From: Beardsworth Robert
Sent: 16 April 2019 09:44
To: Mounce Simon
Cc: Development Control; Hampel Philip
Subject: 19/00333/FULL and 19/00334/LBC EDG, Castel buildings, proposed hotel

Application Number: 19/00333/FULL
Proposal: Application for full planning permission for the demolition and partial rebuilding of the Earl de Grey public house; erection of link extension to Castle Buildings and the Earl de Grey; external alterations to Castle Buildings; use of relocated Earl de Grey, Castle Buildings and link extension for café or restaurant (A3) and/or drinking establishment (A4) and/or office (B1a); the erection of a nine-storey hotel; new public realm and associated works, including landscaping, car parking and servicing, and associated infrastructure.
At: Land To The North Of Castle Street And South-East Of Waterhouse Lane, Including Castle Buildings And The Earl De Grey Public House
Kingston Upon Hull
HU1 2DA

Application Number: 19/00334/LBC
Proposal: Application for listed building consent for demolition and partial rebuilding of Earl de Grey Public House; erection of link extension to Castle Buildings and Earl de Grey; refurbishment, reconfiguration of, and external alterat

Figure 5 – Existing and Proposed Site Plans

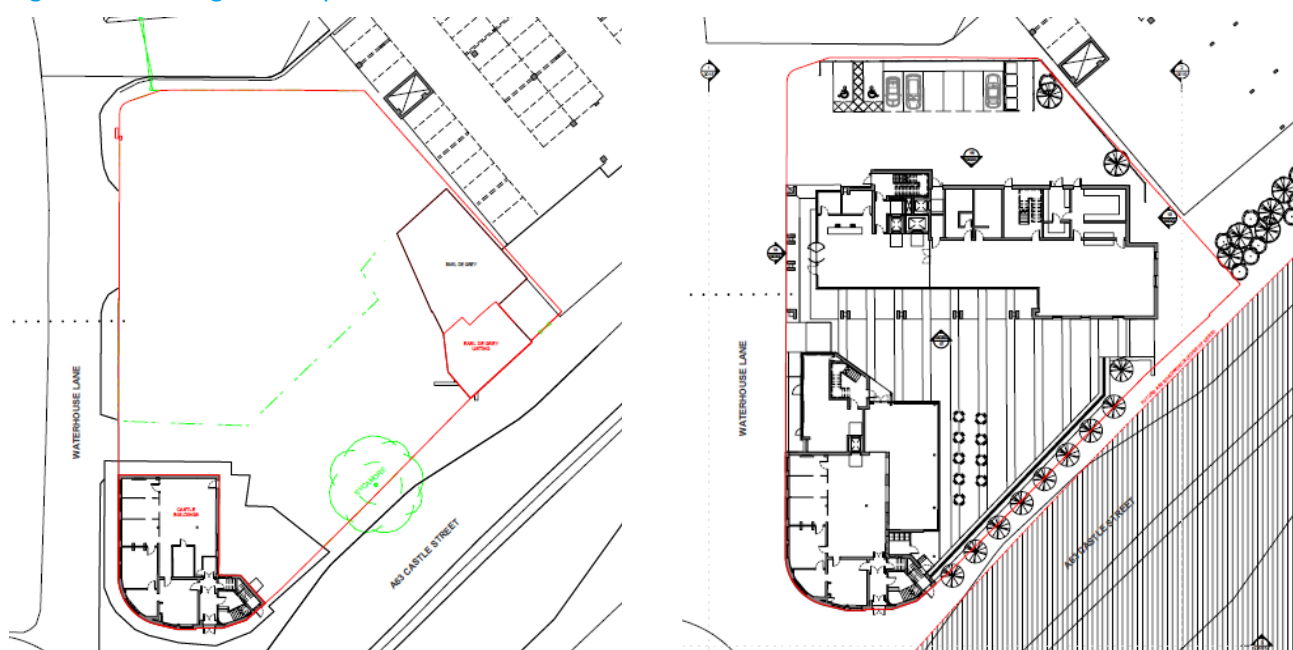
- The proposal is to recess the Earl de Grey from the back edge of the Waterhouse Lane pavement thus stepping it back from the building line formed by the Castle Buildings and the proposed hotel (colonnade). I strongly recommend the building is brought forward to create a consistent and uniform building line. The Earl de Grey is the most diminutive of the three buildings and recessing it back, even slightly, has resulted in it looking subordinate in the street scene relative to its proposed neighbouring buildings. Furthermore, by recessing the Earl de Grey it exacerbates the juxtaposition in height with the proposed 9 storey hotel and reinforces the idea that the Earl de Grey is at the bottom of a hierarchy relative to the other buildings. Whilst its decorative façade carries it so far, bringing the Earl de Grey forward to the common building line will ensure its prominence in the street scene and hierarchy (level access into one, or all, of the entrances can still be achieved without the need to recess the building).

- For the reasons stated above I strongly recommend the Earl de Grey is brought forward to create a consistent building line to Waterhouse Lane with the Castle Buildings and proposed hotel.

Figure 8 – Screen to A63

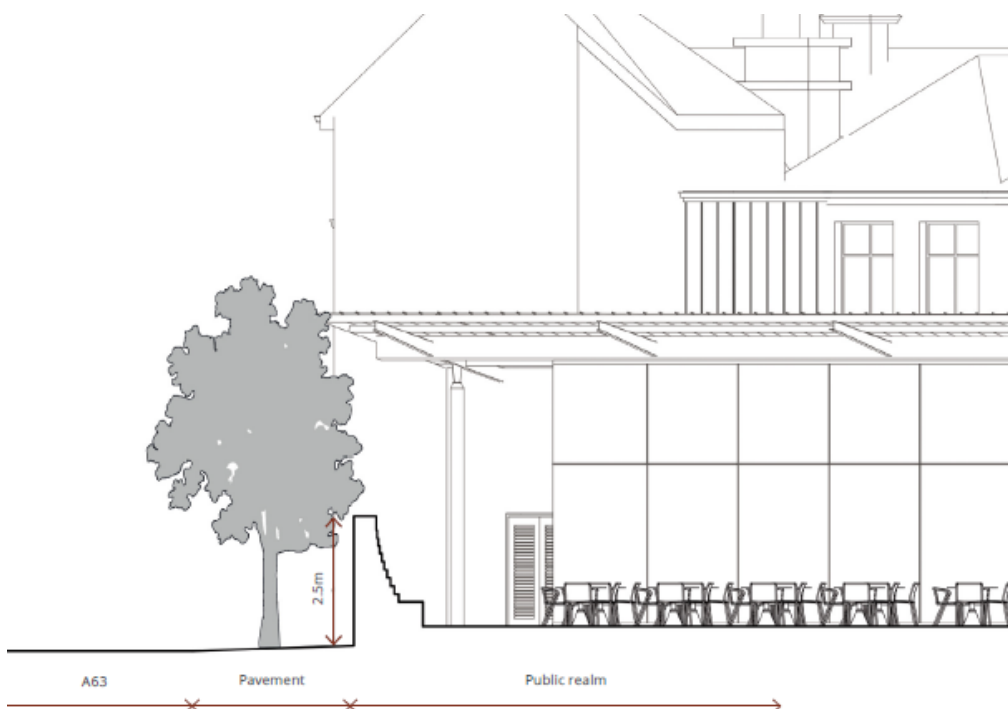
The application pack lacks a drawing of sufficient detail depicting the proposed wall/barrier to the south of the site which will provide an all-important acoustic and visual barrier benefiting the space – especially if this area is to be used for outdoor eating/sitting etc.

- Further design detail (drawing) is required in relation to the proposed wall/barrier to the south of the site which will provide an all-important acoustic and visual barrier to the A63.

Fig 9: Earl de Grey Ground Floor Plan (approx. extent of listing in red)

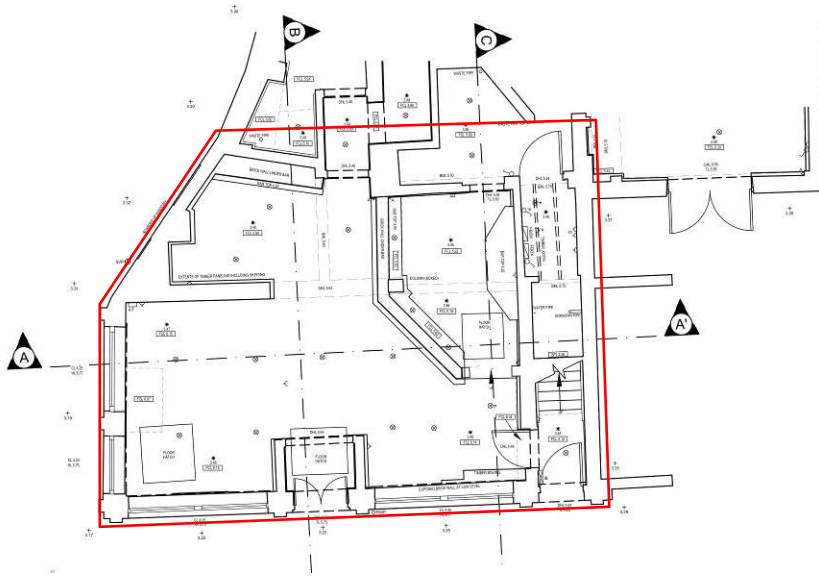
- Location of the proposed stairwell compromises (albeit slightly) the floor area of the room that traditionally has been the 'front room' or 'tap house' of the pub. Can the staircase be reconfigured and relocated to the modern extension (glazed link building) thus removing this element from the listed part of the building? Doing so would unburden the footprint of the listed Earl de Grey and enable a more flexible approach to its future use. It is important to state that the Earl de Grey's story is as much a part of its special character as its faience façade, and a significant part of the justification for relocating it from its original position (on the face of it causing substantial harm) is that the proposed development will safeguard the future of the public house to be enjoyed in the future. Whilst future use/operators may not be determined at this time, proposals should have the highest regard for preserving the Earl de Grey in a way that also maintains its special character and significance as a public house.

- For the reasons given above I recommend the design team seek an appropriate solution for relocating the proposed internal staircase from the listed part of the Earl de Grey into the modern extension.
